I want to submit my comments regarding planning applications 2021/1089 & 2021/1090, which will be spread under several headers and covering a variety of areas – some of which are still present from my first submission in 2021.

Residential Plan – The first Plot

BARNESLEY WEST PHASE 1 | BOUNDARY SECTIONS

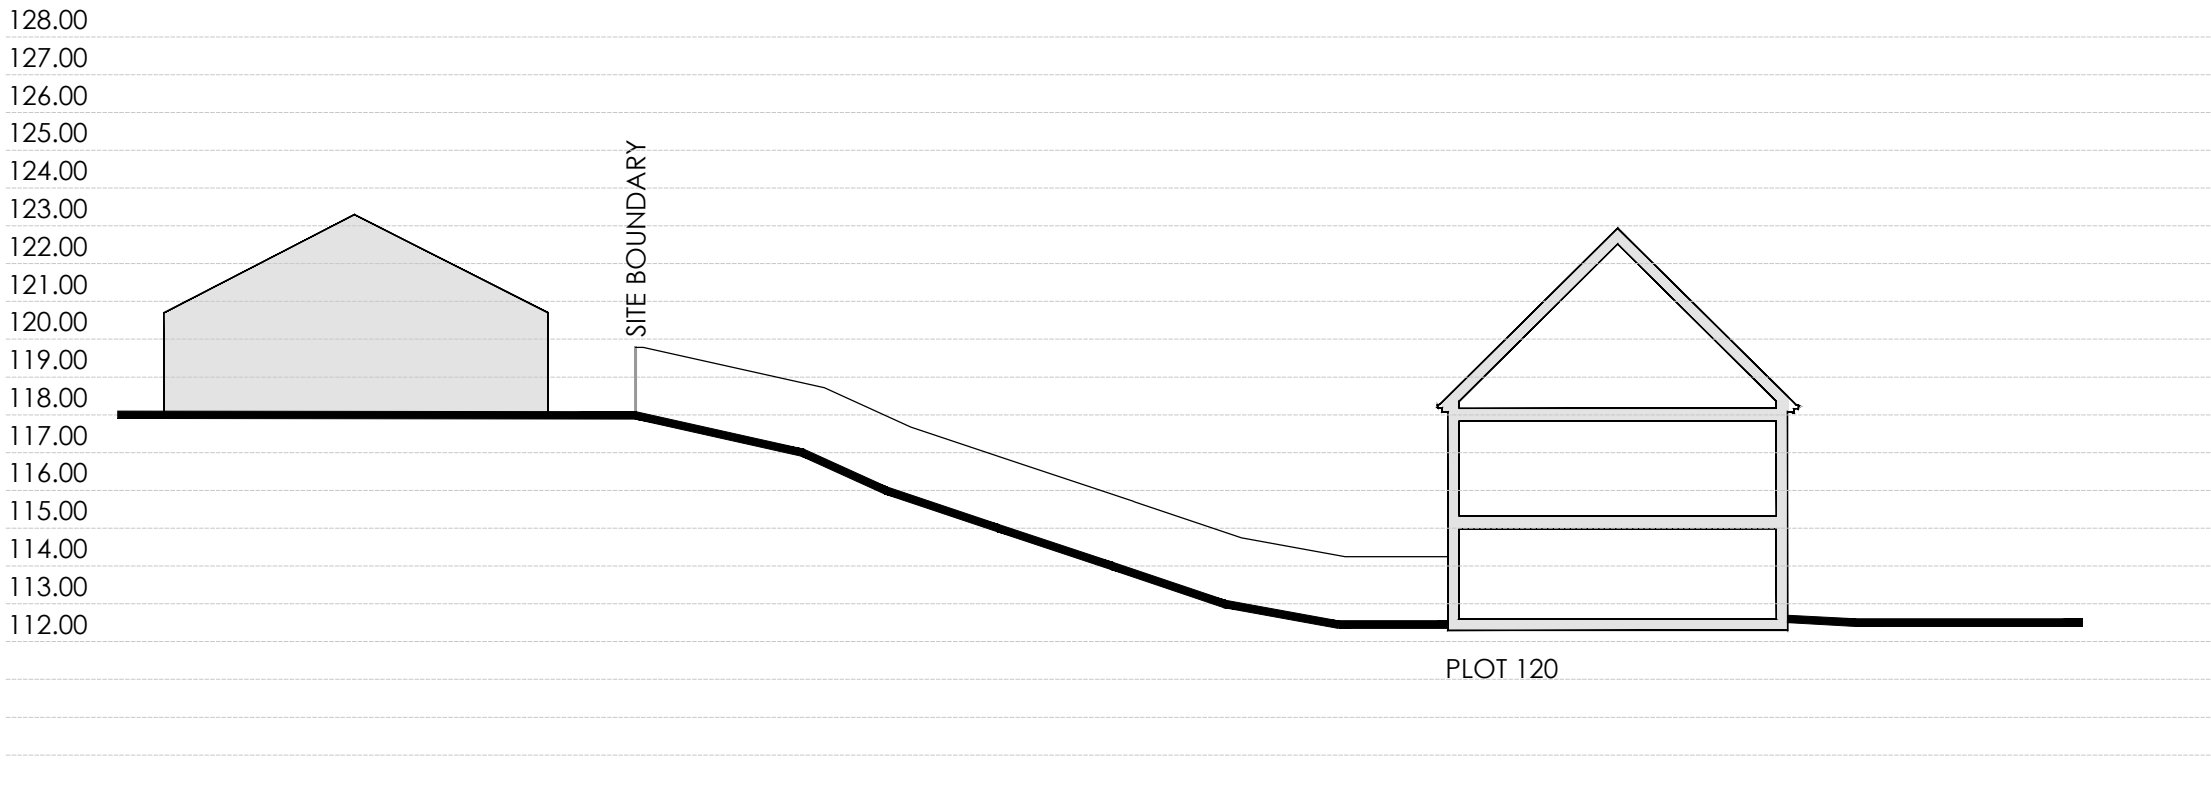
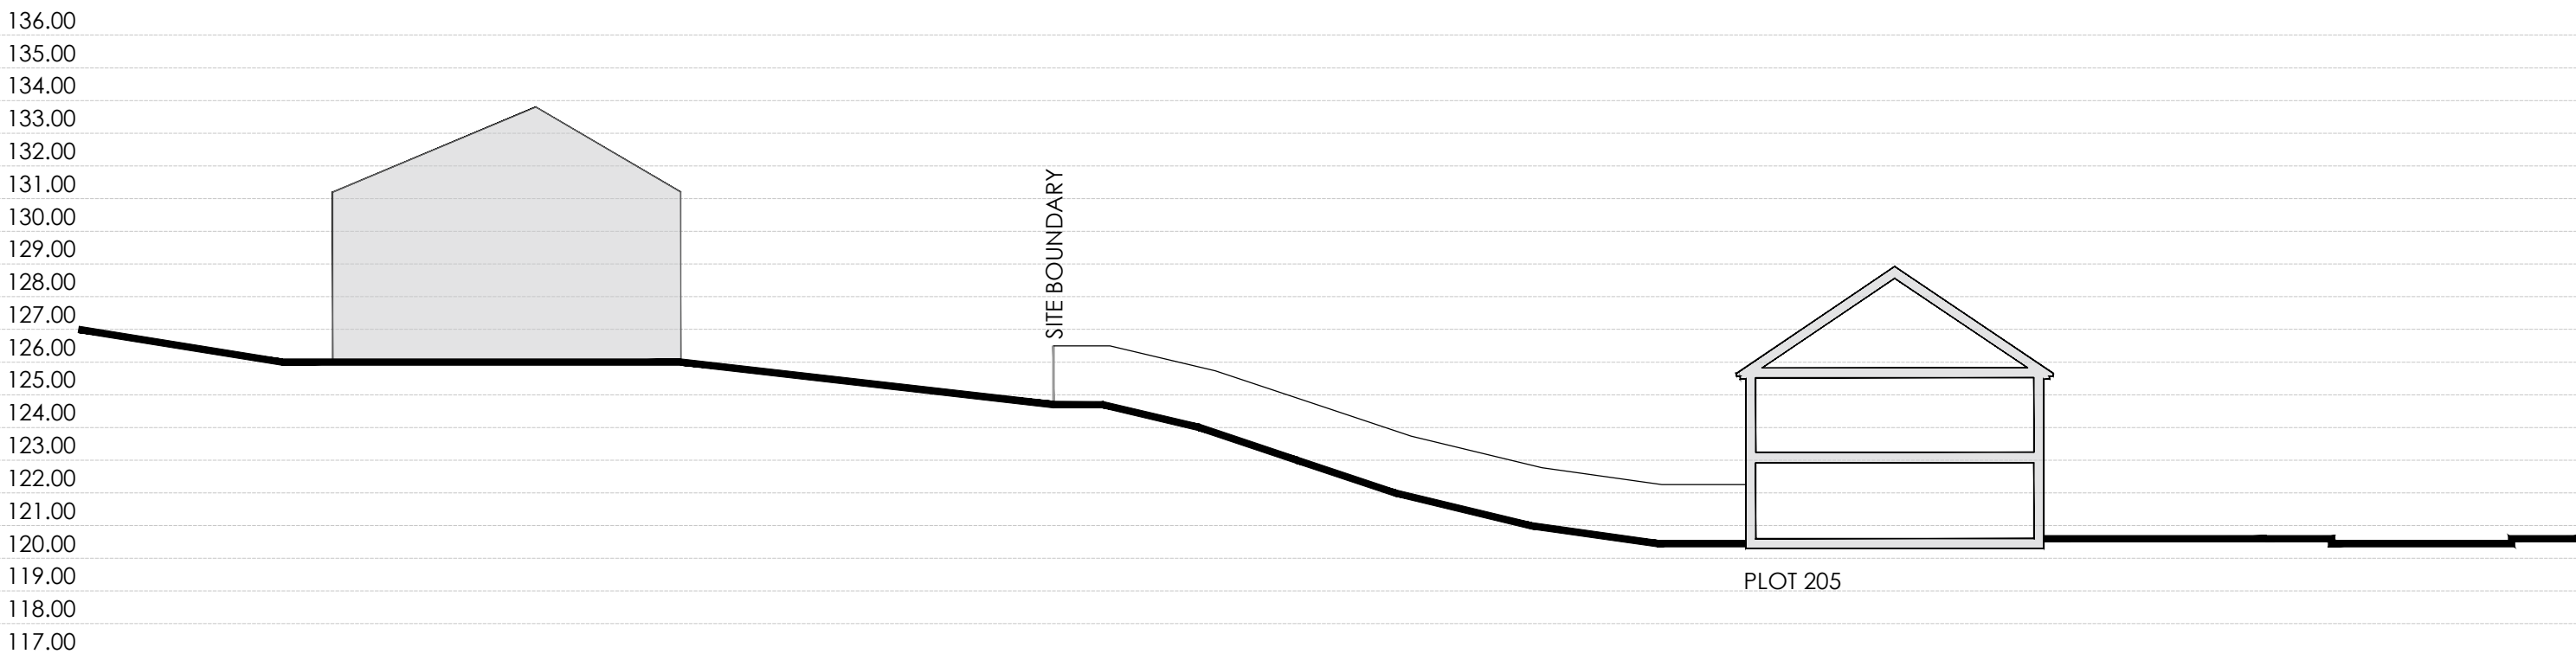
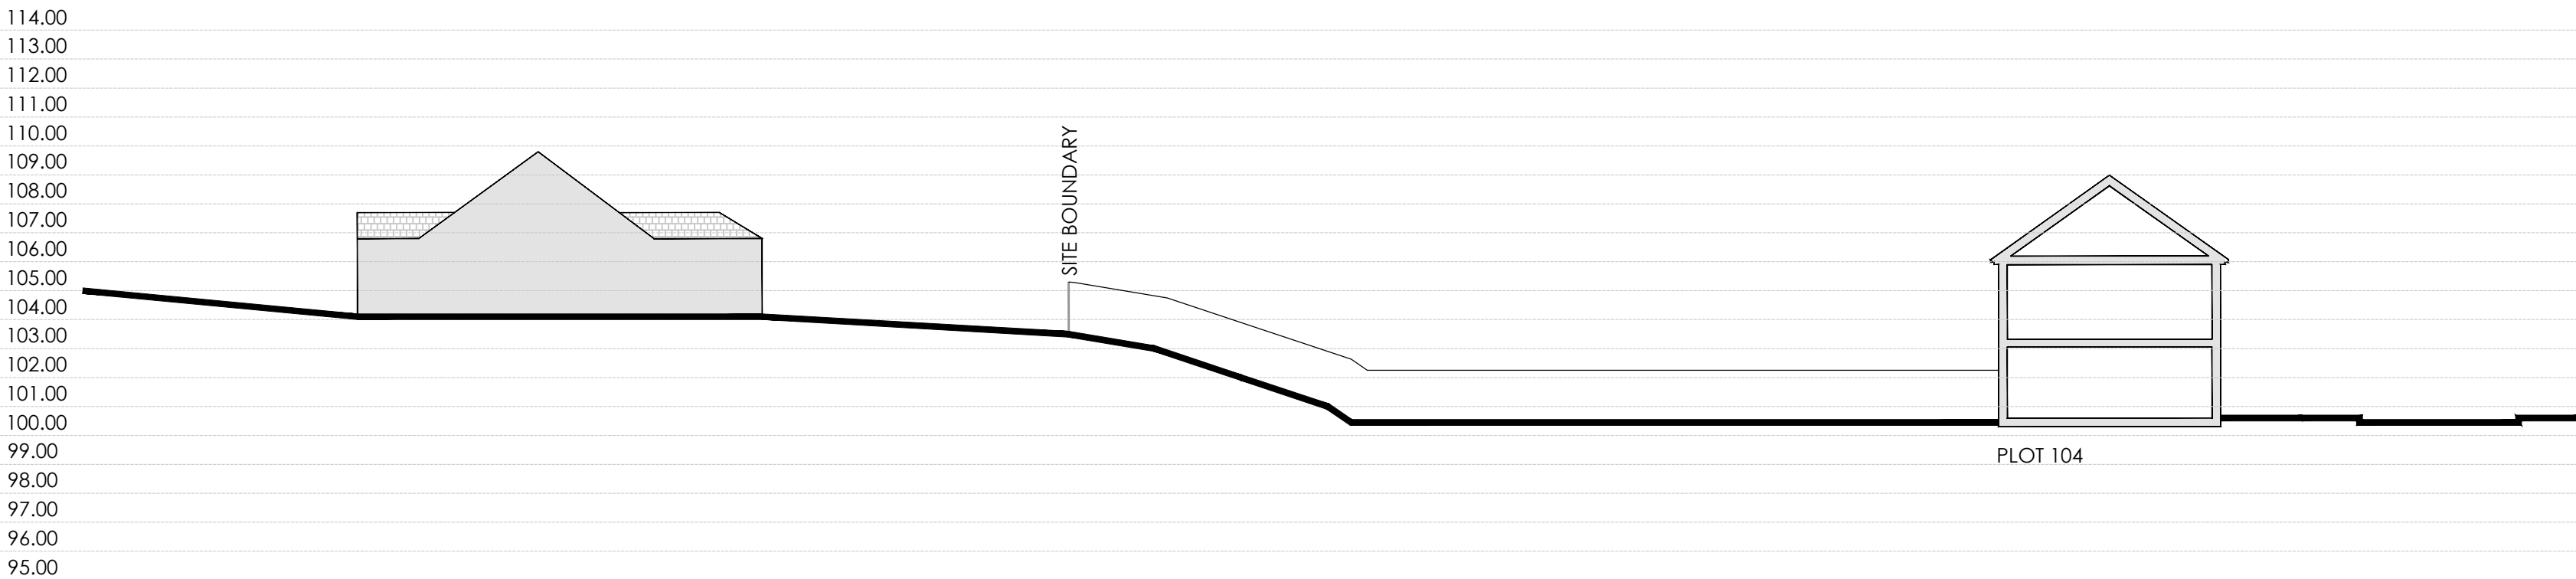
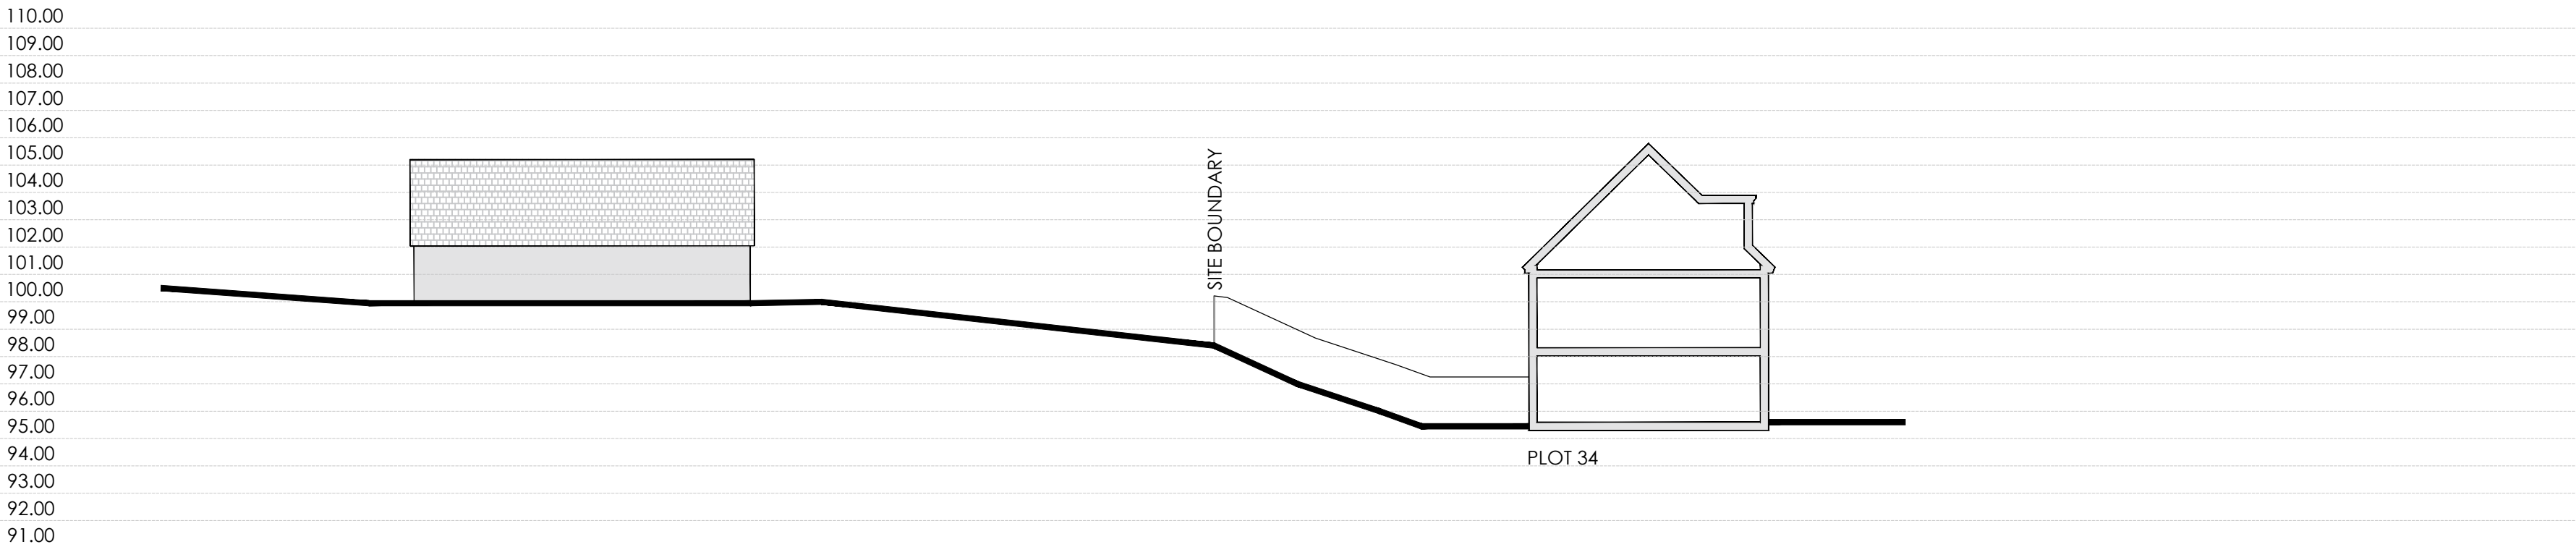
I will repeat a concern and repeat my annoyance of assurances broken. Councillors and BMBC were assured that no three-story houses would be backing up to the bungalows on the western side. As specifically seen in the Phase One residential development plan, this is still false.

Semantics could be used that these are “2.5 stories”, but the harsh reality is that this is a third story, and houses, as seen in the residential plot, meet this. Specifically, these are houses 117, 118, 119, 185, 189, 190, 196, 197 and 200. My residents want their privacy respected, and this plan blatantly opposes that.

Furthermore, residents of the Darton West ward on St. Johns Avenue will also see their privacy breached with house 32. This could be the case with houses 95 to 108, though the garden lengths seem adequate to supply the distance.

While not perfect, I have already indicated that this could have been prevented by a buffer zone of trees between the houses. That this – and previous assurances – have been ignored, and the privacy of residents in bungalows is being blatantly ignored, is deeply concerning.
